From: Chris Moore [REDACTED]
Sent: 05 June 2026 09:26
To: Nicola Spencer; Planning
Cc: Nick Clews; Julia Clews
Subject: RE: Request for further information AW/79/26/HH
Attachments: Prop Rear Side Elevations.pdf

From: Nicola Spencer <Nicola.Spencer@arun.gov.uk>
Sent: 04 June 2026 22:09
To: Chris Moore [REDACTED]
Subject: RE: Request for further information AW/79/26/HH

PROPOSED FIRST FLOOR PLAN

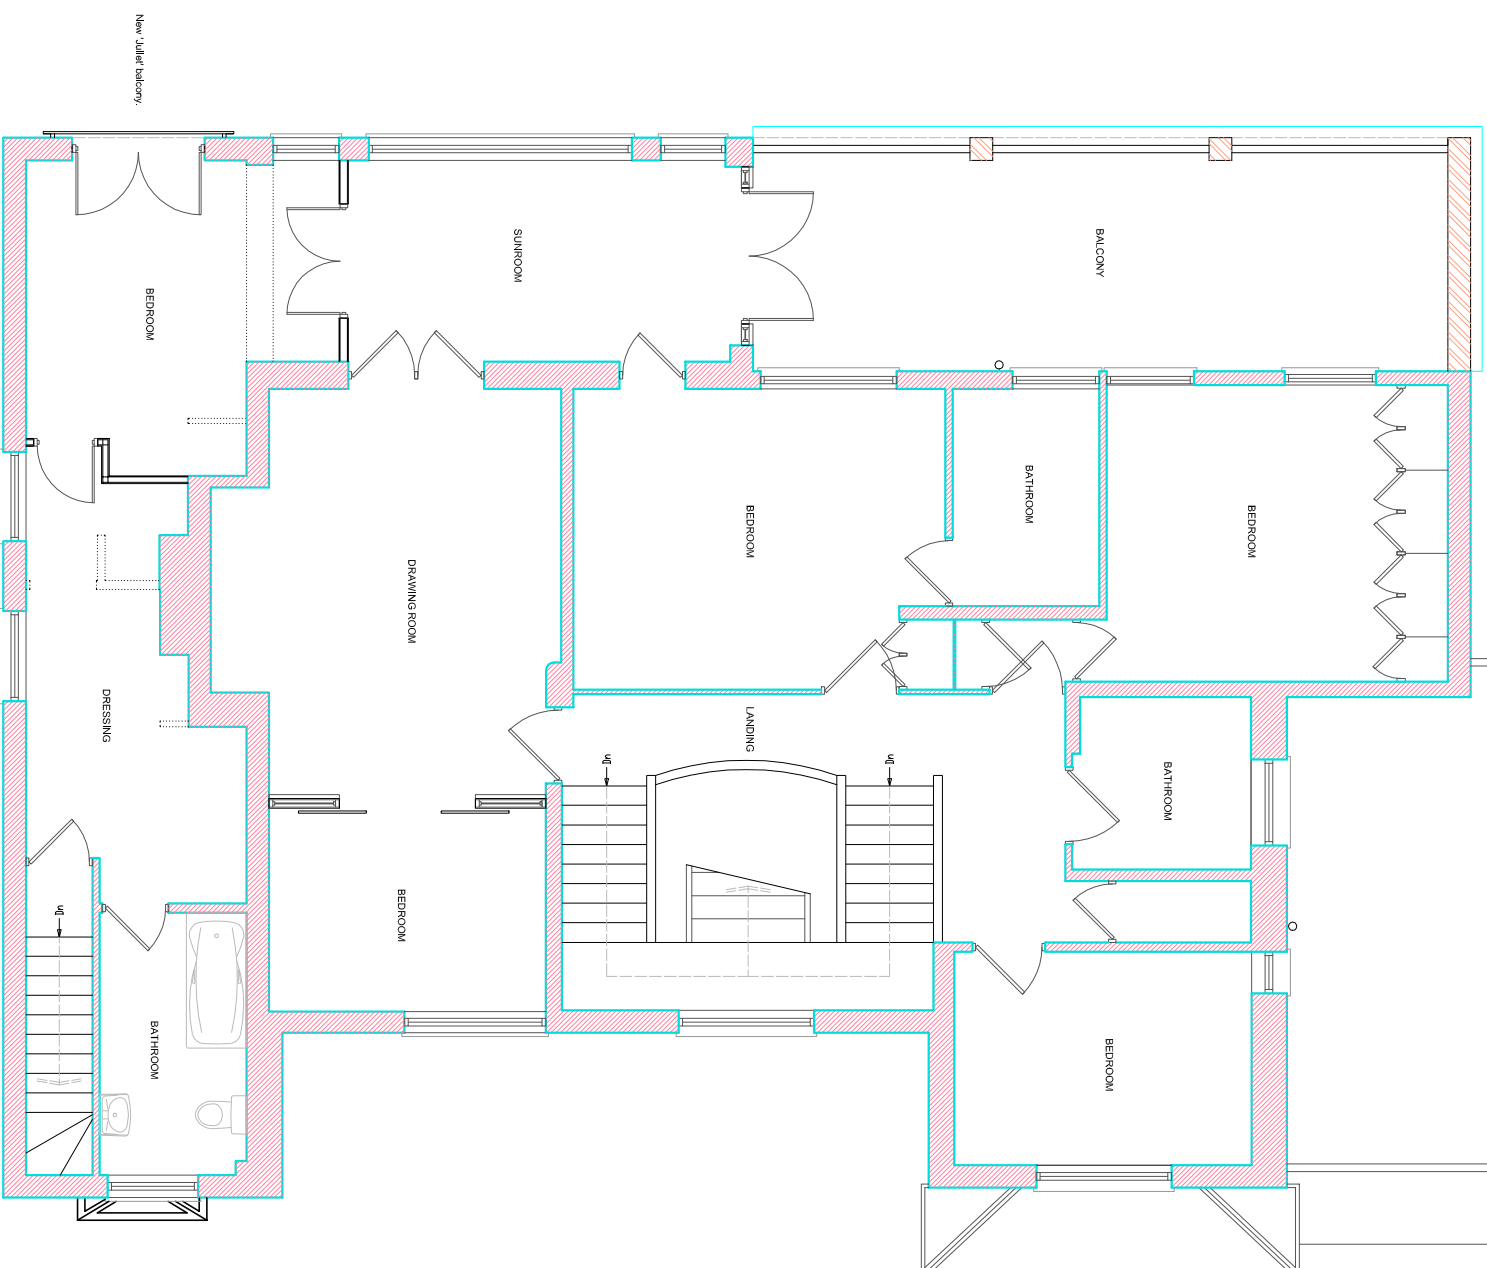
I have just looked at the plans and I think there is still a discrepancy between the first floor proposed floor plan and the proposed right elevation first floor. I think there is a window missing on the floor plan or an extra window on the elevation. Please correct whichever is wrong. I have put some orange boxes on the plans to indicate where I mean.

I attach a copy of the updated elevations – thanks for your help.
